Application No: AB/61/21/L
Site Address: 61 Maltravers Street Arundel BN18 9BQ
Description of works: Listed building consent to reduced chimney height.

OWPC36919

EXISTING ROOF PLAN

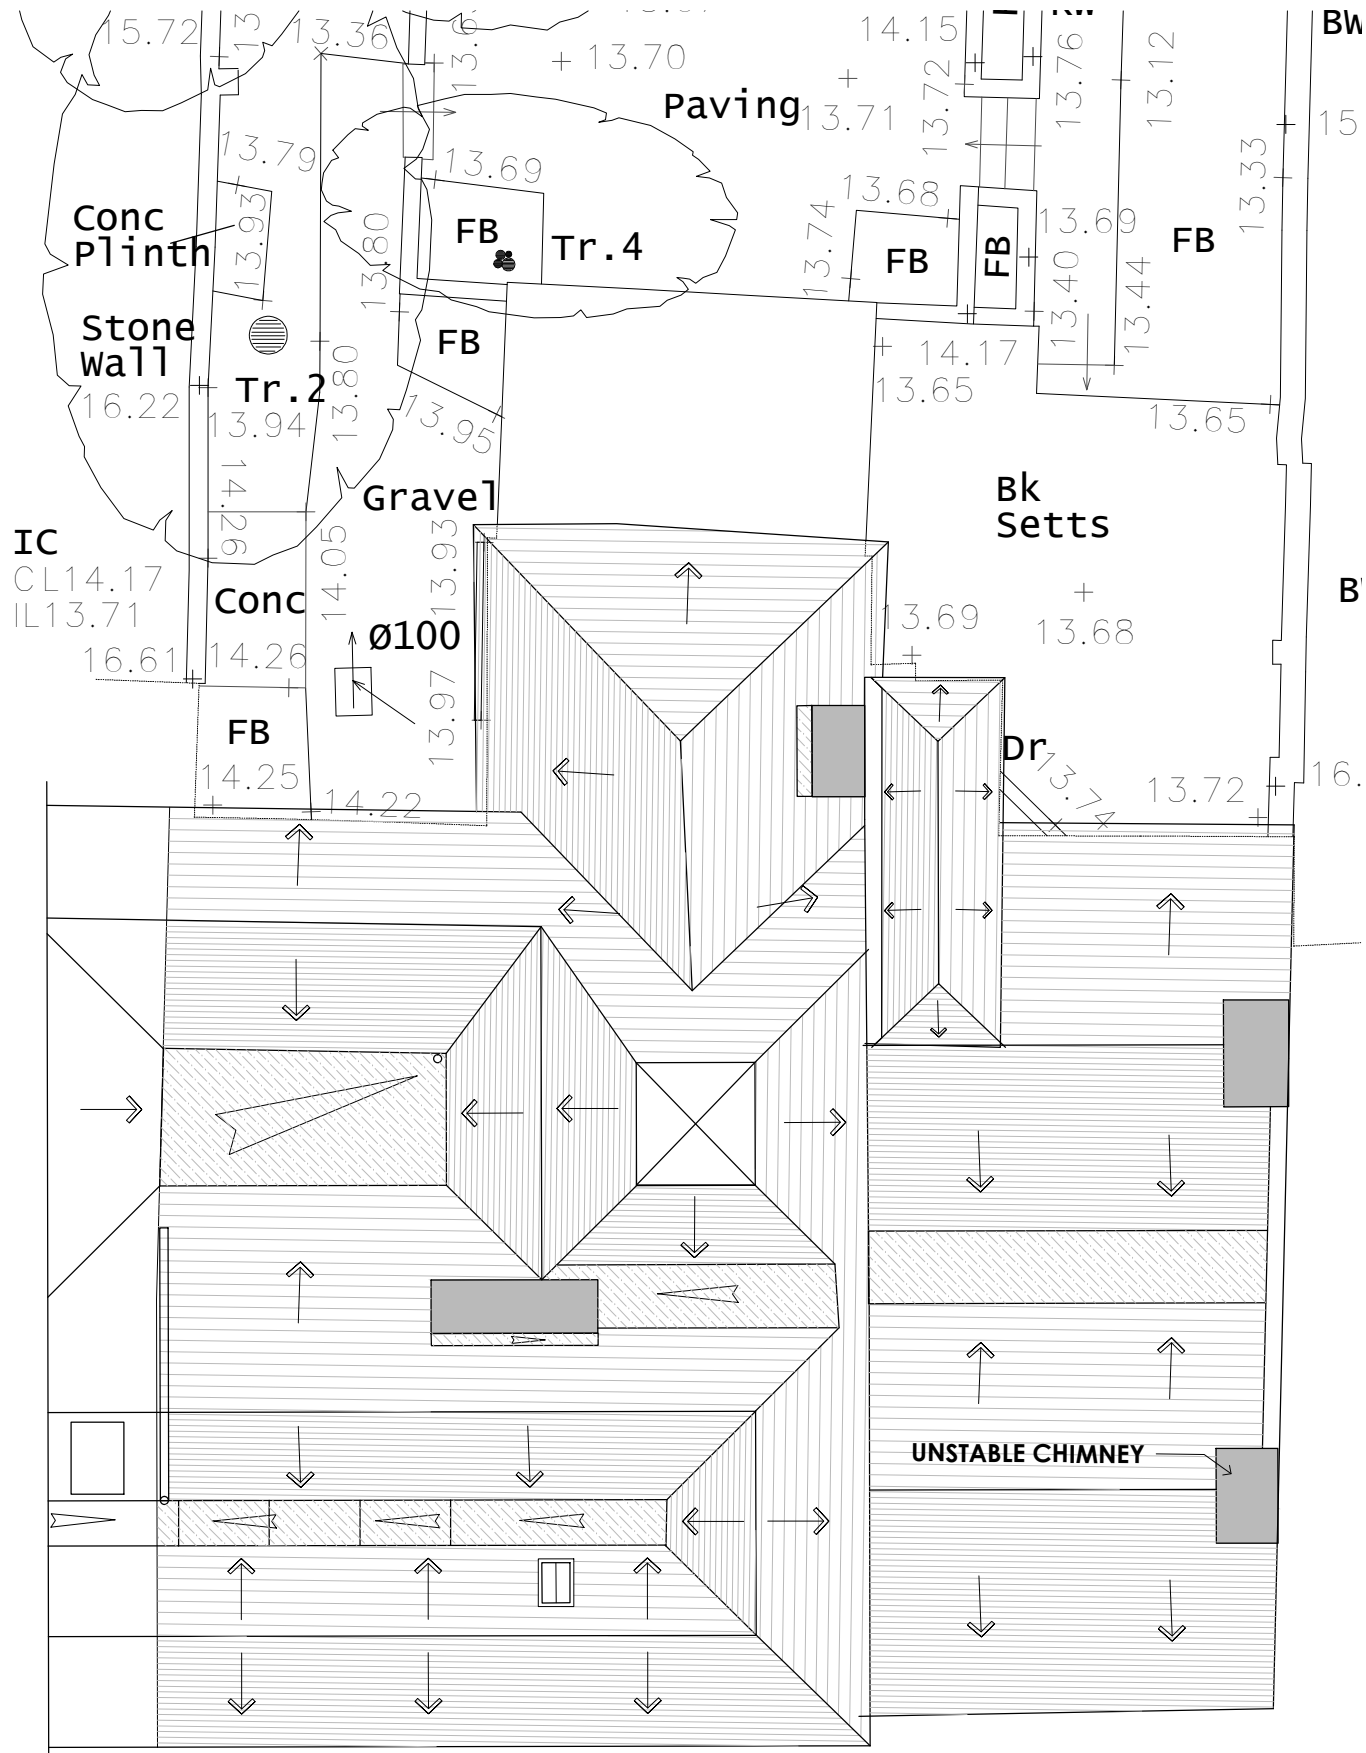
The existing chimney is attached to the 2 storey part of the building and forms a very prominent feature in the Maltravers Street townscape, especially when viewed from the raised pavement on the opposite side of the road.

High chimney stacks are not uncommon features in the streetscenes of the District's historic urban areas. As such, there must be some concern that the grant of consent may set a precedent for similar works elsewhere which would impact on the District's historic environment.

For these reasons the preference is that the chimney is rebuilt to its original height, but in a safe manner.

However, the Panel are not in a position or are qualified to dispute the conclusions that, structurally, the chimney requires to be reduced in height for safety reasons. Its comment of no objection is based on the assumption that there is no alternative but to undertake the works proposed in the application.
